Submission on Reference: SSD 5066/EPBC 2011/6086 Provided by Allan Corben 13 Woolmer's Court Wattle Grove NSW 2173 P/N 0451 998 774 Email allancorben@bigpond.com

Chapter 11 Traffic, transport & access.

Figure 9.18 Proposed intersection layout – I-13

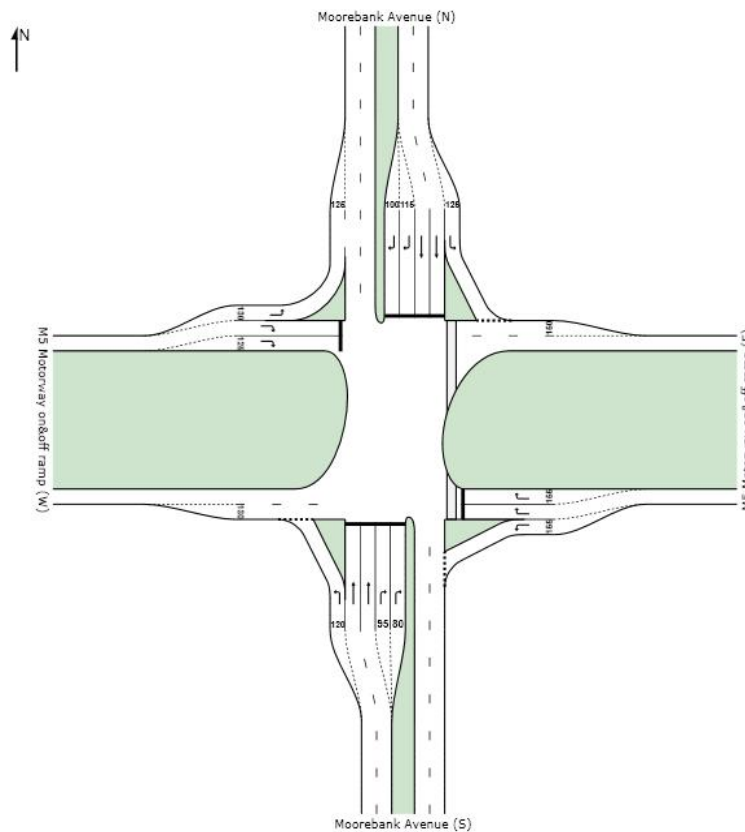
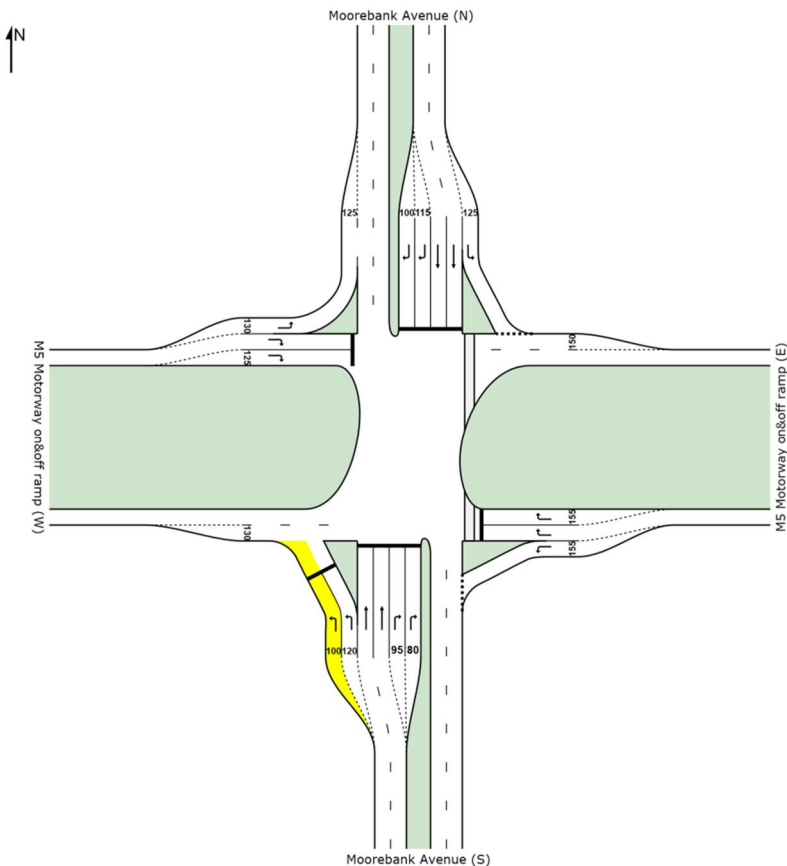
Pages 30 & 31 Figure 11.7 & 11.8 AM & PM road network traffic volumes generated, **shows virtually no increase in vehicle movements AM or PM at the Moorebank Ave/M5 interchange east or westbound regardless of the fact that the Intermodal will bring the equivalent of the following cars into this intersection daily, 2023 = 17,597, 2028 = 20,878 & 2030 = 30,204 It is a well-known fact that this intersection is the worst traffic impacted intersection. This prediction is very questionable.**

The interchange of Moorebank Avenue and the M5 Motorway would perform satisfactorily, maintaining a LoS C or better performance during the AM and PM peak hours in 2030. However, the DoS of 0.99 during the AM peak hour indicate that the interchange would be operating at capacity. ***This statement is highly questionable. This intersection is currently at capacity in the PM movements. Moorebank Ave/M5 interchanges needs to be well and truly upgraded prior to any operations commencing.***
